MEMORANDUM

Project: PA23031 – Riverwalk SLP

Date: February 20, 2024

RE: Proposed Modification to Fill Plan for Riverwalk Properties

Drawing No. **SP1**  
 Sheet No. 2 of 3

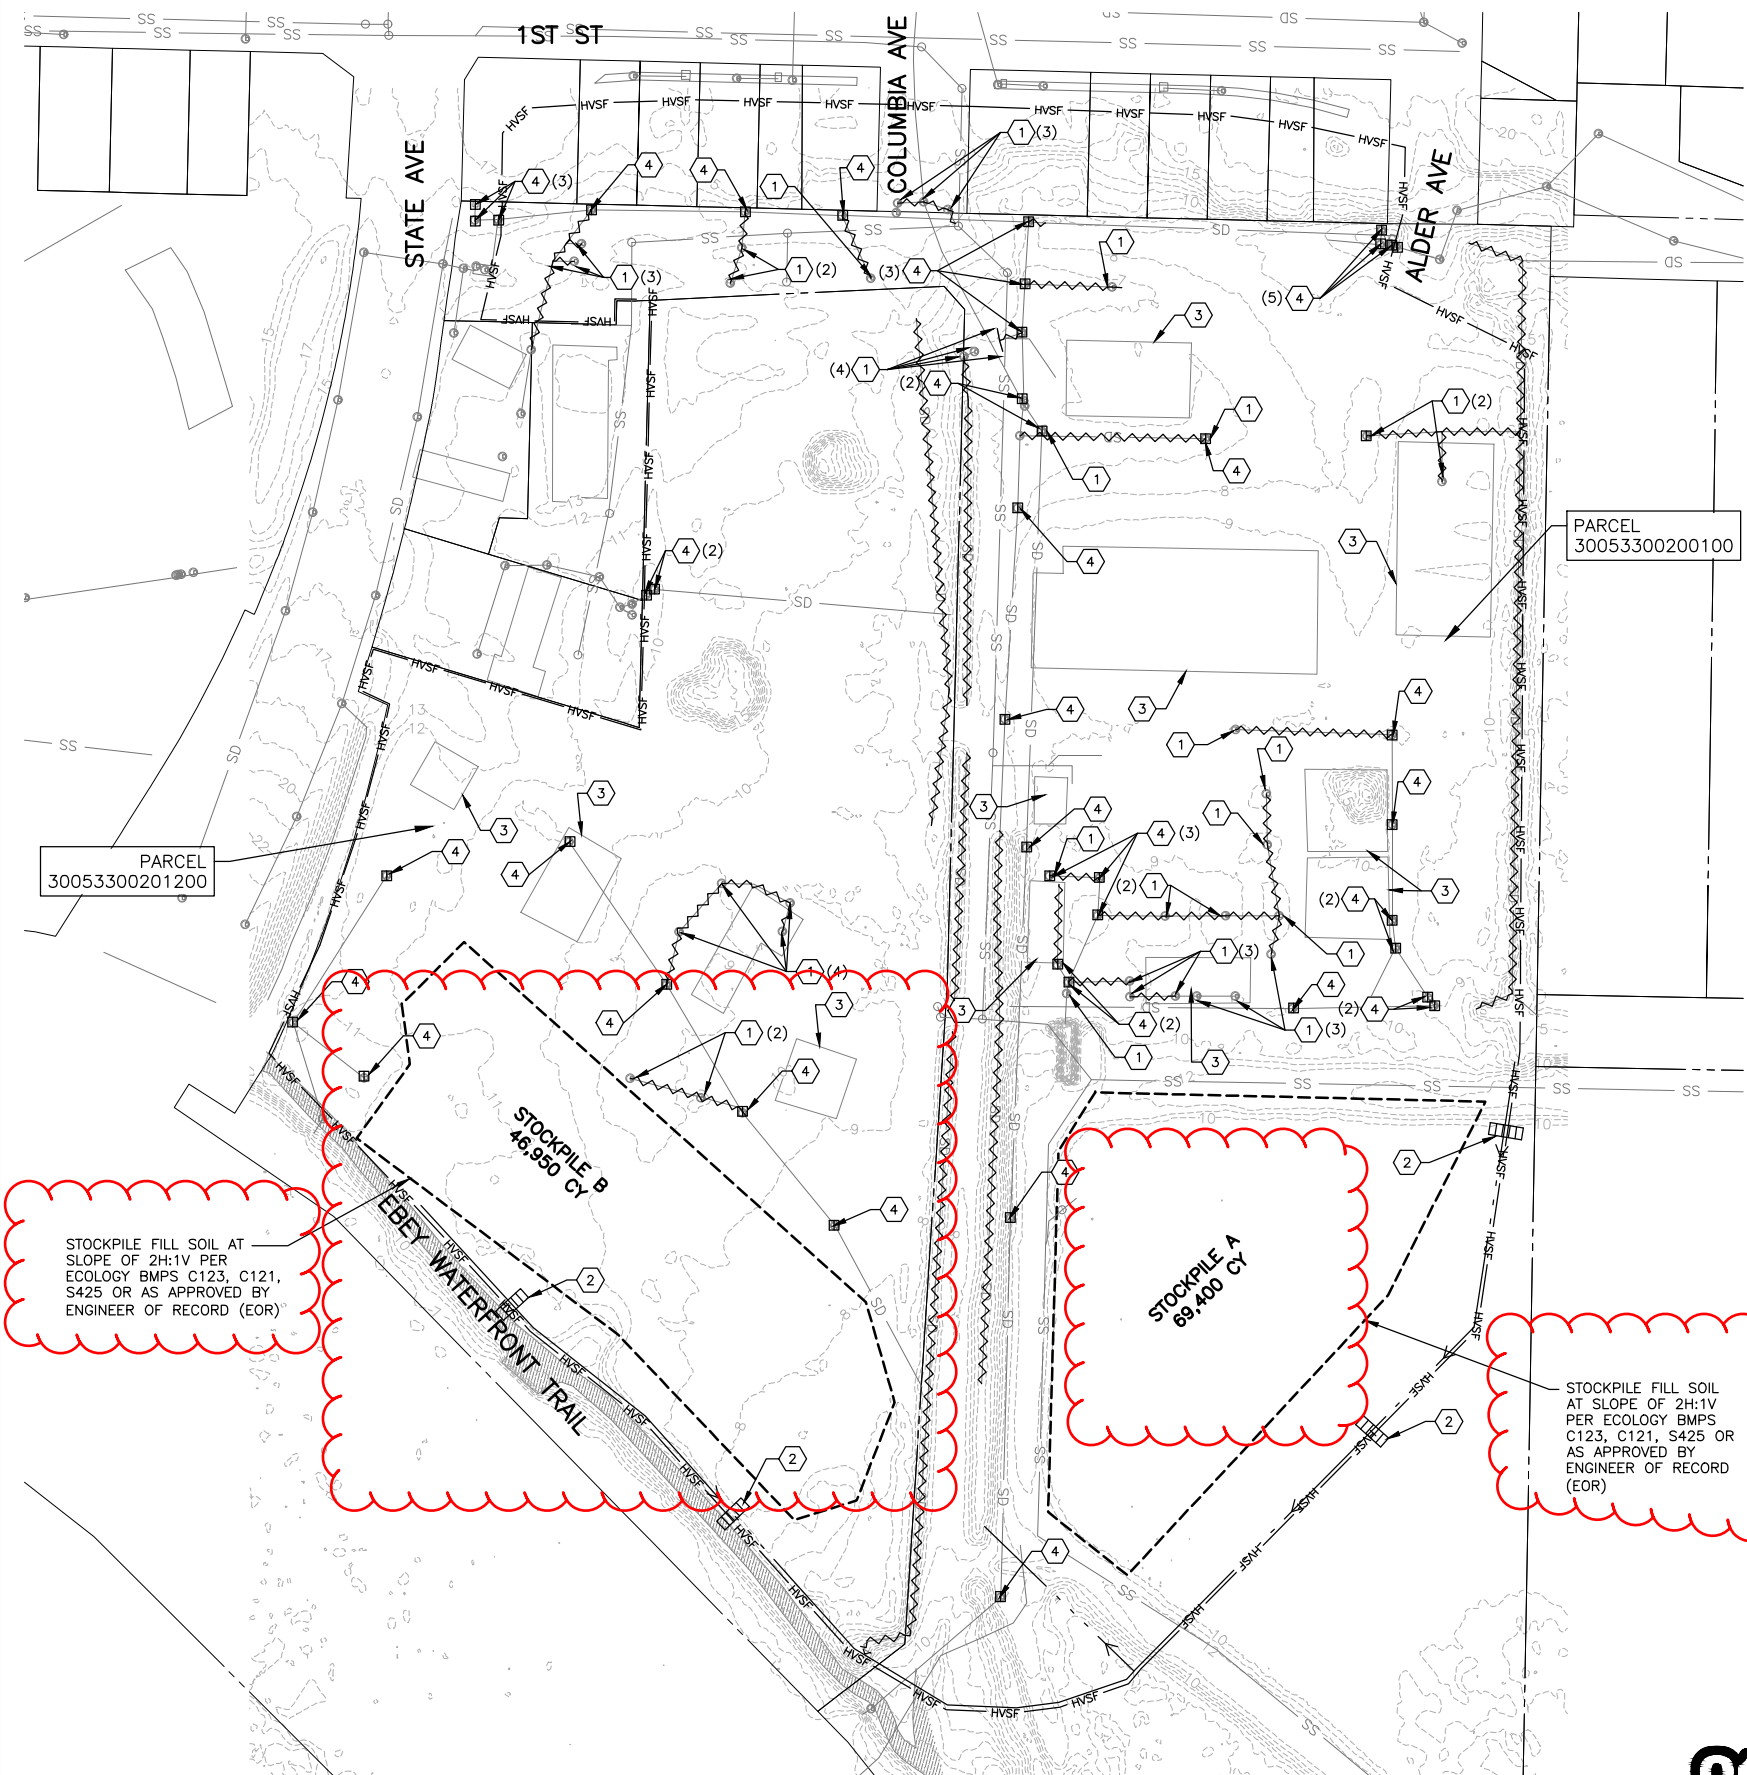
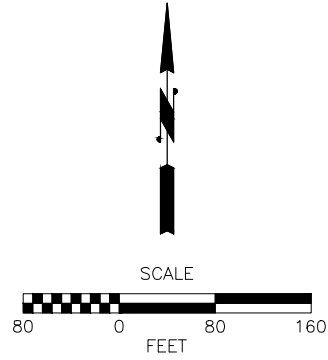
To accommodate the stockpile requirement, Perteet has modified the grading plan to show designated stockpile locations and additional BMPs needed to meet temporary sediment and erosion control requirements. The revised grading plan is attached for your consideration.

In addition to the stockpiling revisions, the City determined the installation of walls along the eastern and western boundaries would best be performed by the future developer. From this decision, Perteet has revised the grading plan to remove walls, adjust grading to 2v:1h along these edges and install silt fence as the appropriate BMP to address temporary erosion and sediment control requirements. The soil needed to fill behind the future walls will be stored in the stockpile locations shown on the revised grading plan.

Drawing No.  
**GR1**  
Sheet No.  
3  
of Total  
3

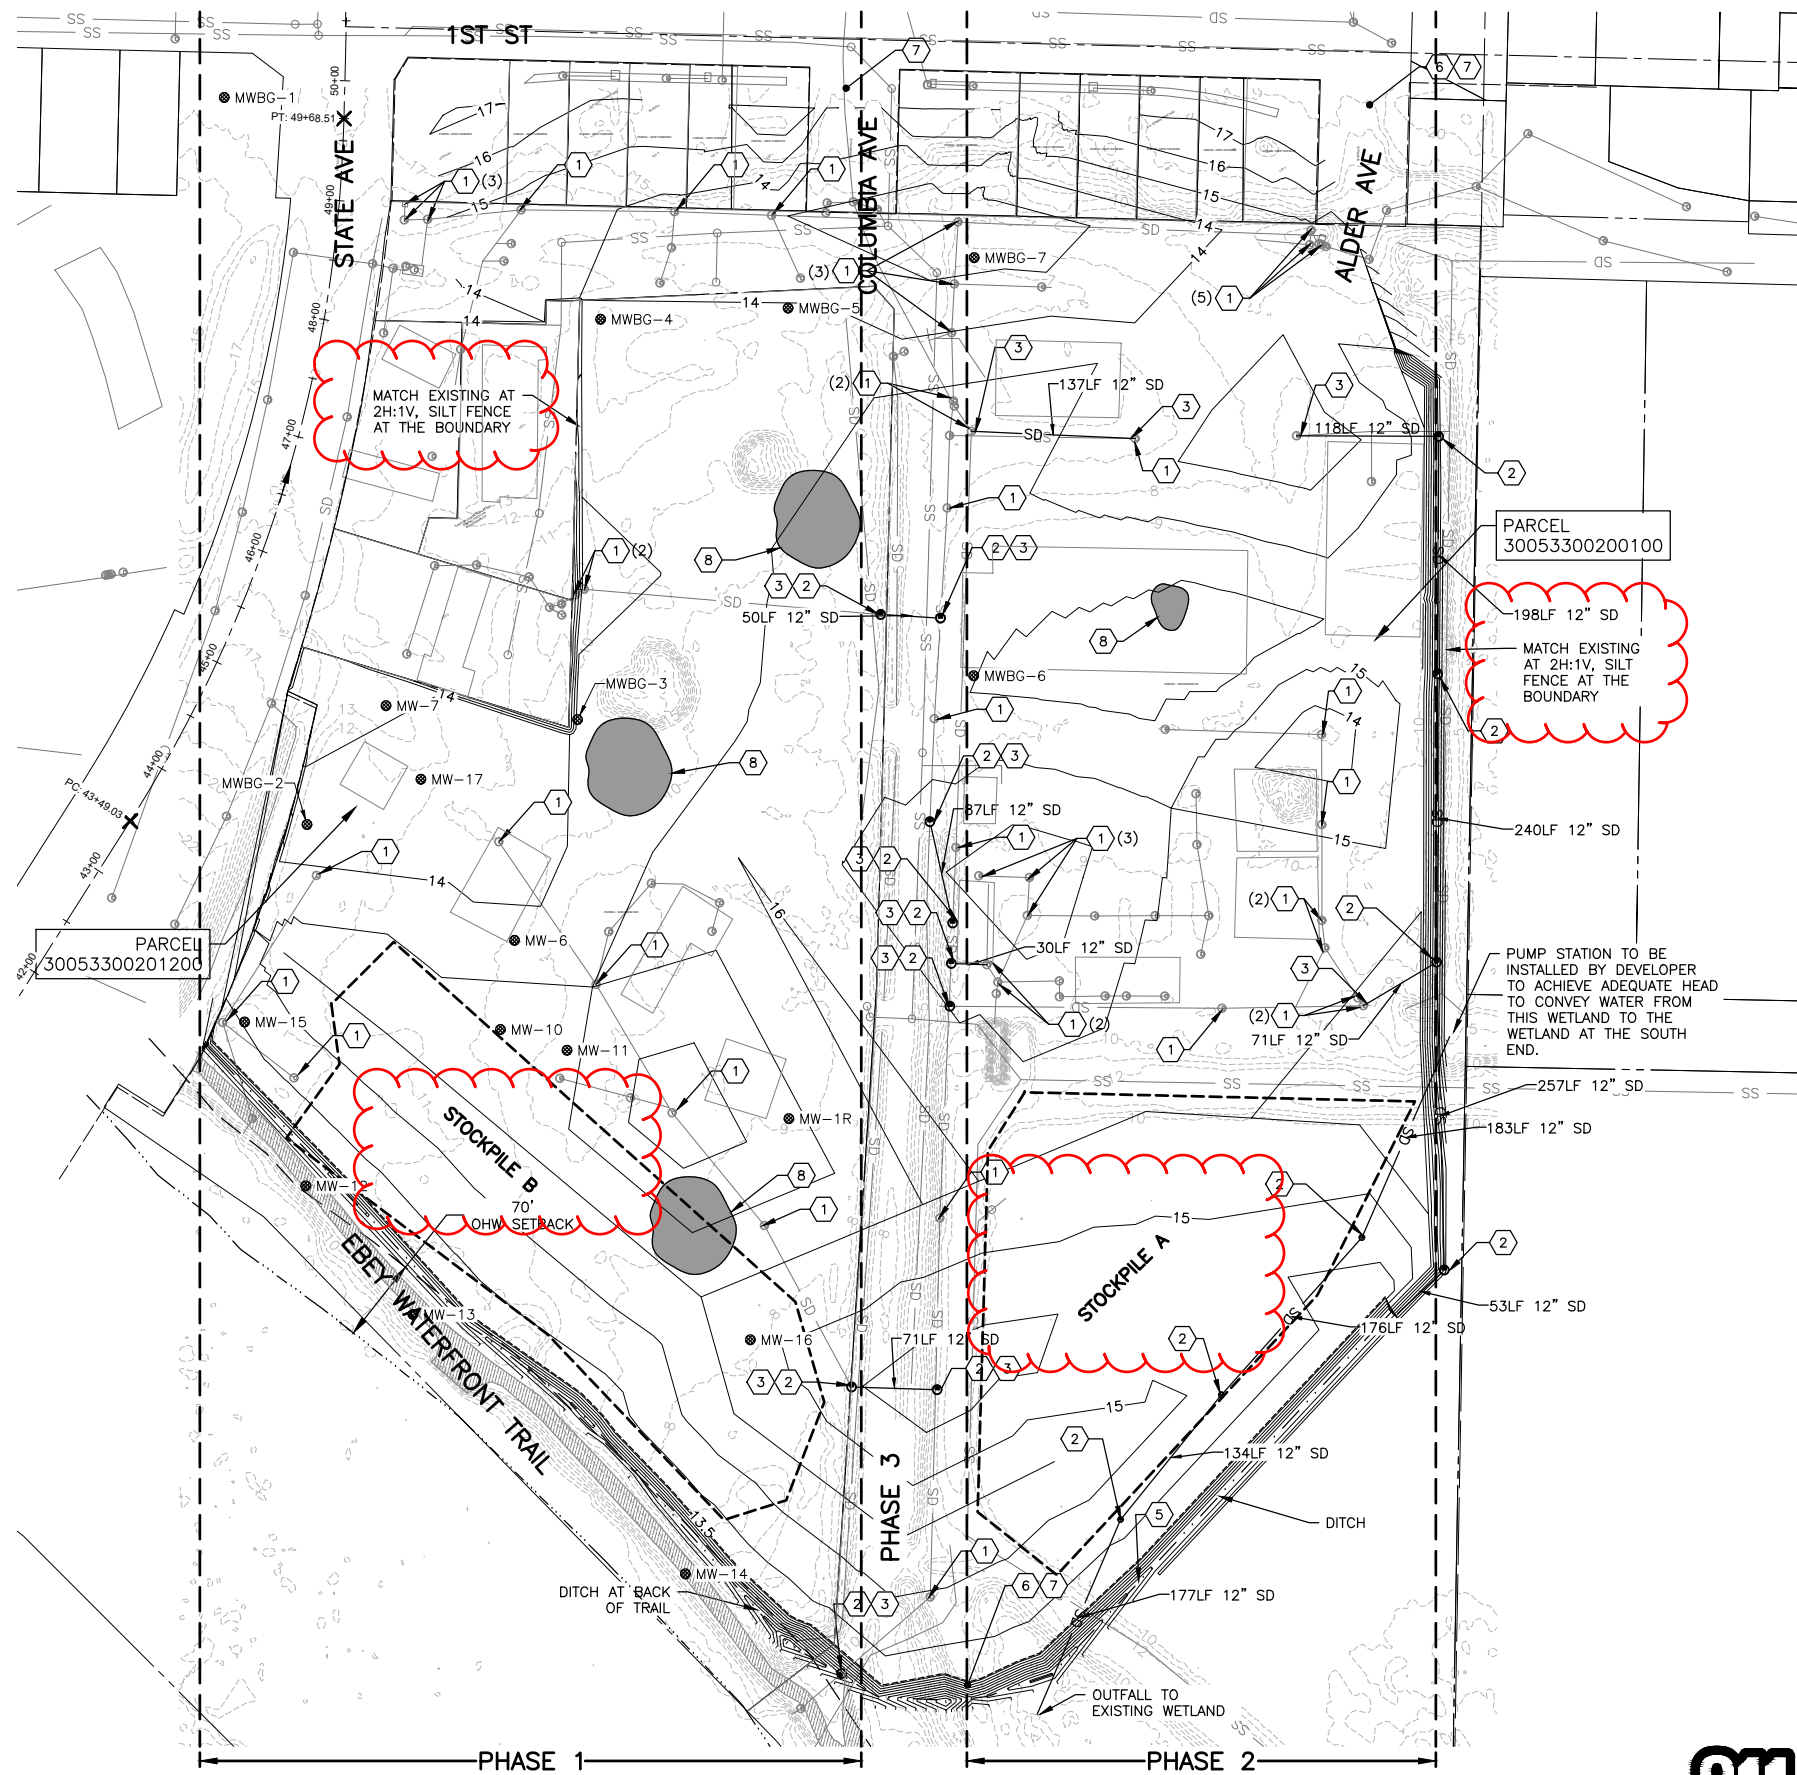
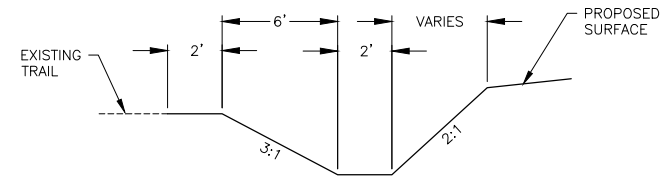
With this memorandum, we are requesting the City replace the existing grading plan with the modified plan dated February 14, 2024 and supplement the grading permit application with the included soil testing information.
